Our ref: XA/2025/100270/04-L01

Date: 7 October 2025

ISSUE SPECIFIC HEARING 2 (ISH2) INTO ENVIRONMENTAL MATTERS

BOTLEY WEST SOLAR FARM, OXFORDSHIRE

Photovoltaic Development Partners GmbH
Kurfürstendamm 52
10707 Berlin, Germany

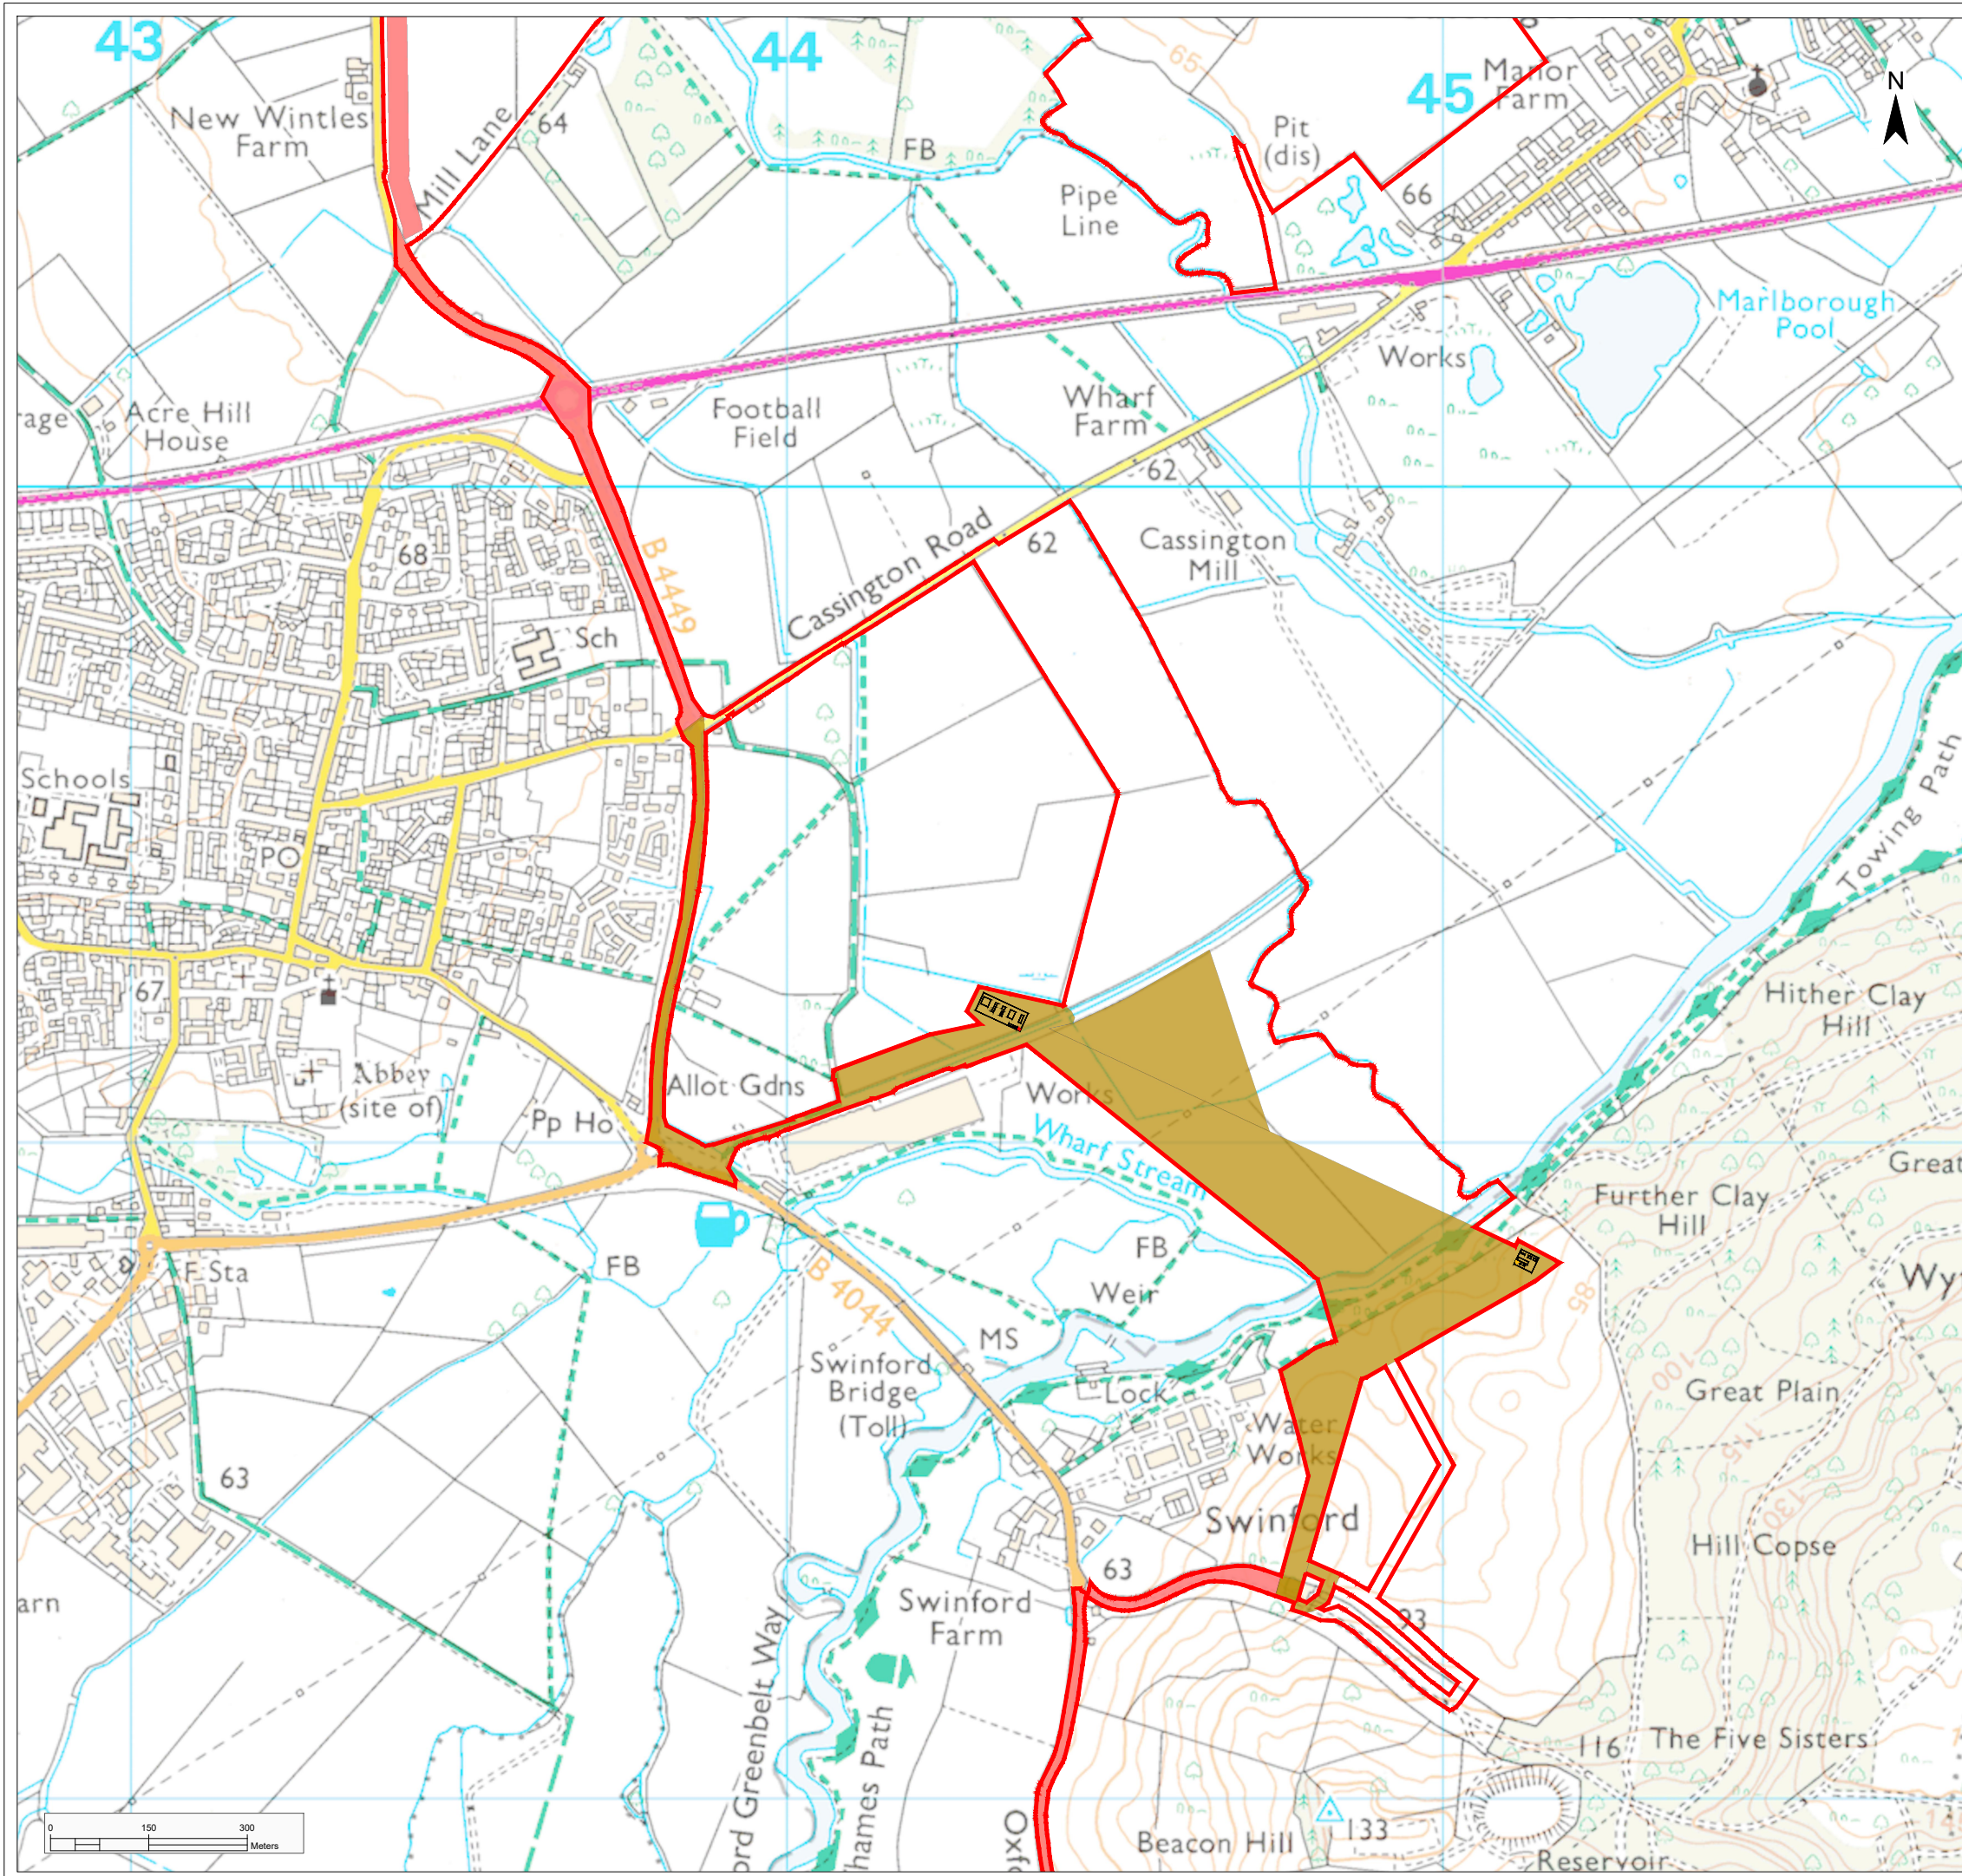
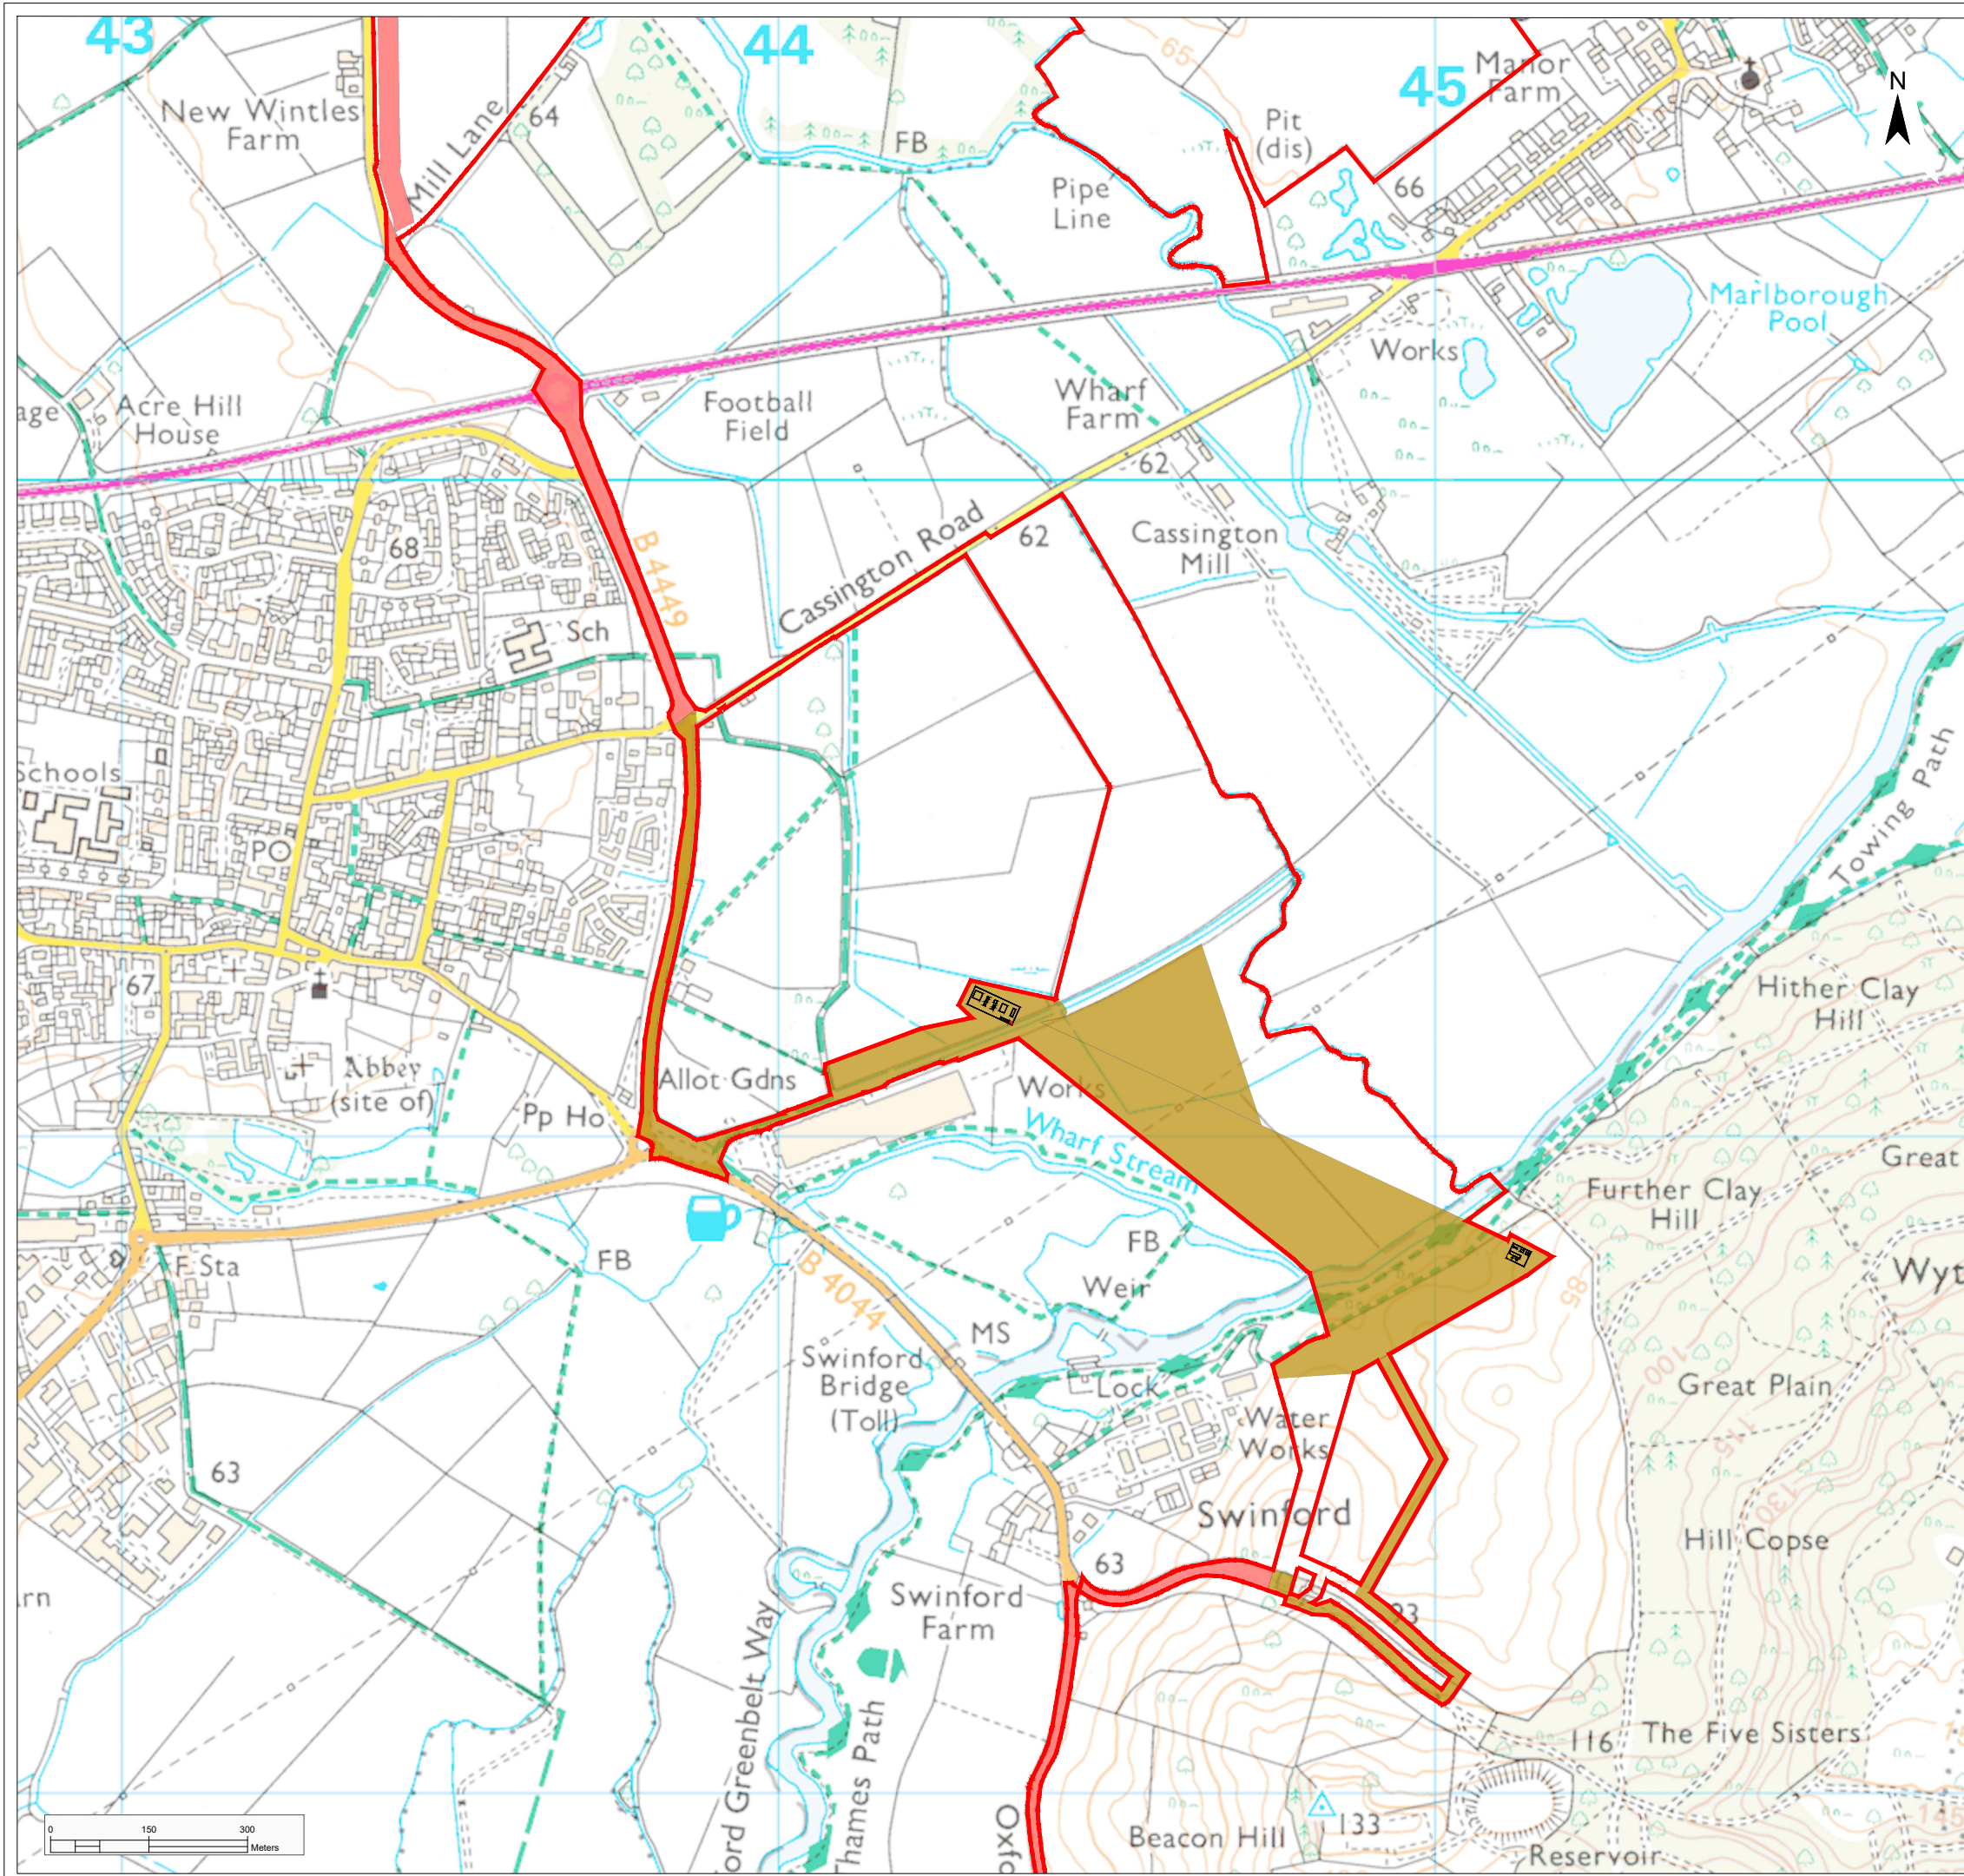
Flood Zones 3a and 3b / ES, FRA	EAFR-009 – Provide mapping that shows Flood Zones 3a and 3b with proposed components and the cable corridor route. Minimise interaction with Flood Zone 3b.					<p>The Swinford HDD entrance pits are shown to be within the extent of Flood Zone 3b within the West Oxfordshire Strategic Flood Risk Assessment. The latest Risk of Flood from Rivers and Sea (RoFRS) dataset shows the chance of flooding from rivers and the sea considering the presence and condition of flood defences. The Swinford HDD entrance pits are at a high-risk classification based on this dataset. A high-risk classification has a greater than or equal to 1 in 30 (3.3%) chance of flooding in any year. I would suggest using the Risk of Flooding from Rivers and Sea dataset for informing the risk to the entrance pits rather than solely the outlines from the River Thames as the RoFRS dataset will incorporate the risk from other watercourses as well such as the lower River Evenlode. In addition to the modelled outlines, the Swinford HDD crossing entrance pits are also shown to be within the Winter 2013/14 recorded flood extent, January 2003 recorded flood extent, and the Winter 2000 recorded flood extent. Given the location of the entrance pits within a high-risk flood area, there is also potential for flood flow routes through the HDD tunnel to the opposite bank of the Thames. The applicant should assess this risk and clearly outline the mitigation measures.</p> <p>The applicant will need to review this with respect to the Swinford HDD entrance pit and provide written justification as to why the entrance pit cannot be moved outside of functional floodplain. In such cases,</p>

<p>appropriate mitigation measures must be presented to manage and reduce flood risk. It is important to note that mitigation measures may remain relevant even if the HDD entrance and exit pits are located within Flood Zone 3a, as this is still an area at risk of flooding.</p>
--	--	--	--	--	--	--	--	---
